**RE: Stone Age Climbing Gym
6200 Alameda NE
Grading & Drainage Plan and Drainage Report
Engineer's Stamp Date: 09/05/19
Hydrology File: C18D086A**

Based upon the information provided in your resubmittal received 09/05/2019, the Grading and Drainage Plan is approved for Building Permit.

**RE: Stone Age Climbing Gym
6200 Alameda NE
Grading & Drainage Plan and Drainage Report
Engineer's Stamp Date: 08/19/19
Hydrology File: C18D086A**

1 | grading and drainage plan
c101 1"=20'

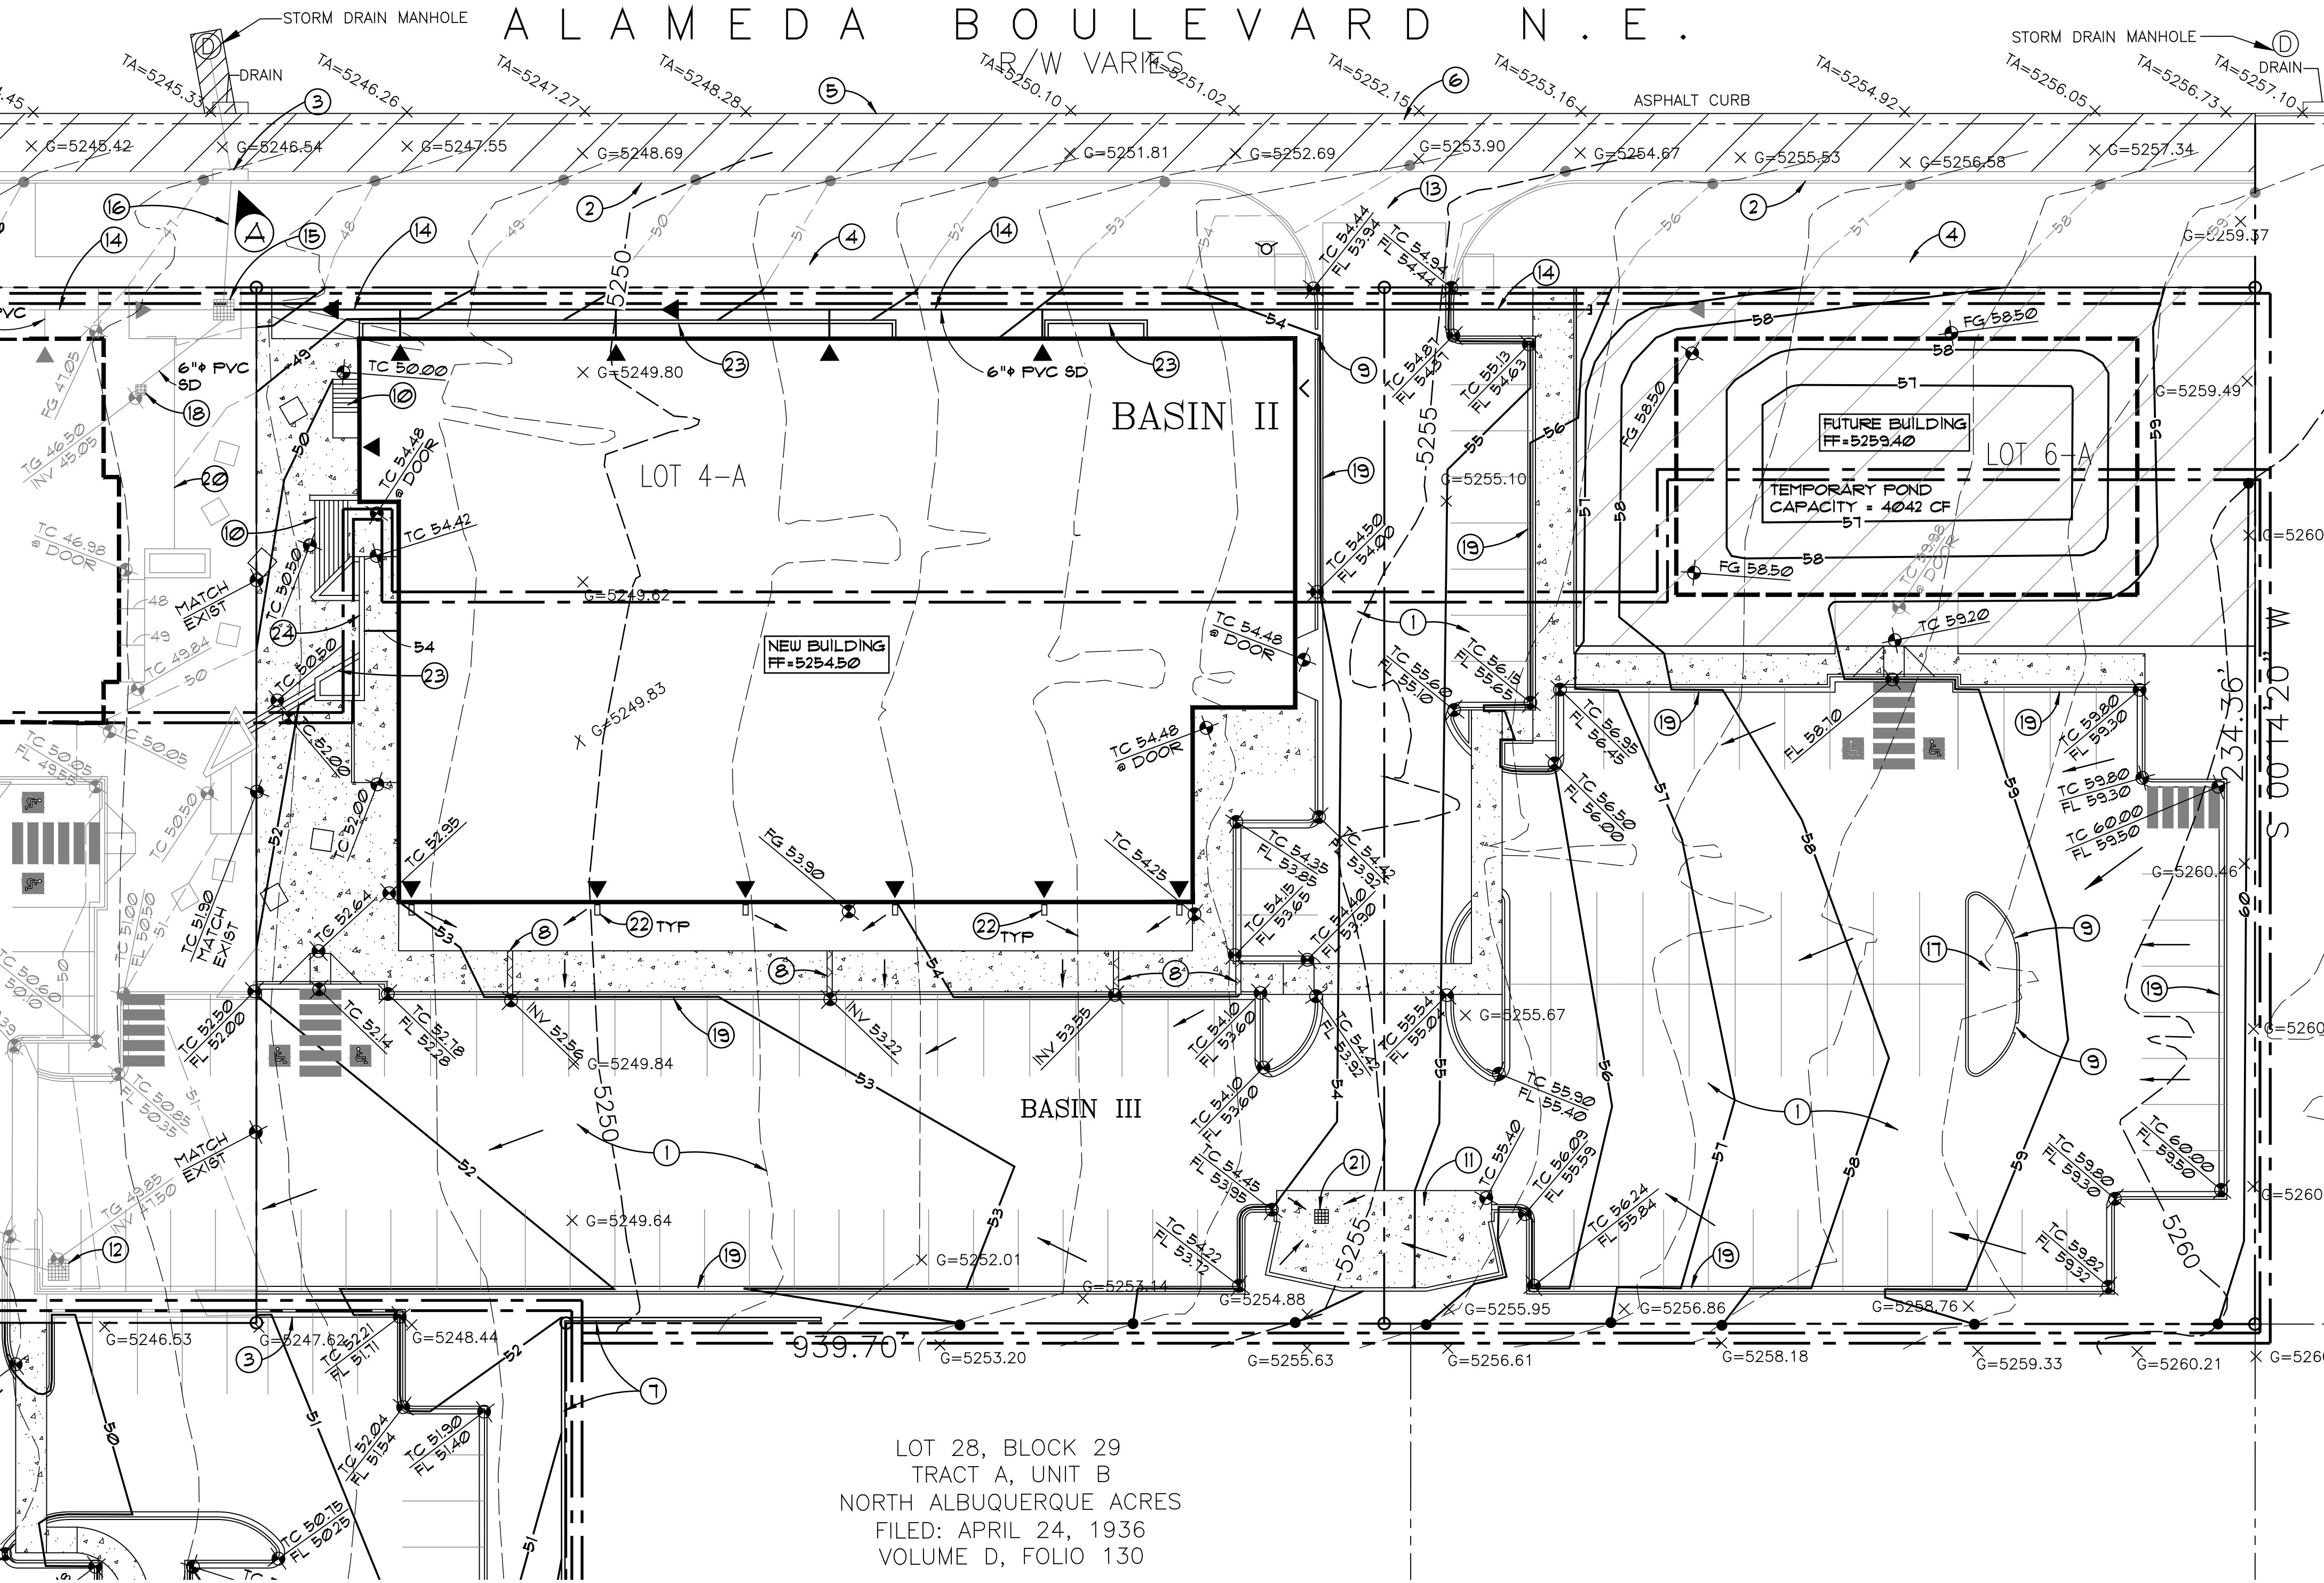
1. Grading & Drainage Plans. There is a temporary retention pond at the area of a future building near the northeast corner of the development. I do not see any purpose for the retention pond. There will be no drainage going into this pond. This area should just be graded for the future pad of the building.

2. Grading & Drainage Plan. Under the Drainage Points, "C" should be 4.02 cfs. This will match the drainage for Basin I in the Ultimate Development.
3. Grading & Drainage Plan. The proposed grate in Basin I is too high and needs to be at the southwest corner of the parking lot. This location is where all the drainage from Basin I is flowing towards. By leaving the inlet as shown, there will be pool of water collecting at the southwest corner of the parking lot. Please fix.

1. While we do not have a great deal of runoff directed toward the future building pad site on Lot 6-A there will still be some flow developed on this site and so the pond has been reduced but will stay to prevent erosion to Alameda Blvd.

2. Drainage Point 'C' was incorrectly noted and has been corrected to 4.02 cfs.
3. The Basin I grate has a top of grate elevation approximately 1.25 feet lower than the high point of the water block in the drive access to Signal. This was done to provide a small amount of ponding in that corner of the parking lot should the runoff directed that way momentarily overtax the catch basin and grate, or the storm drain outlet to the Signal Ave. storm drain.
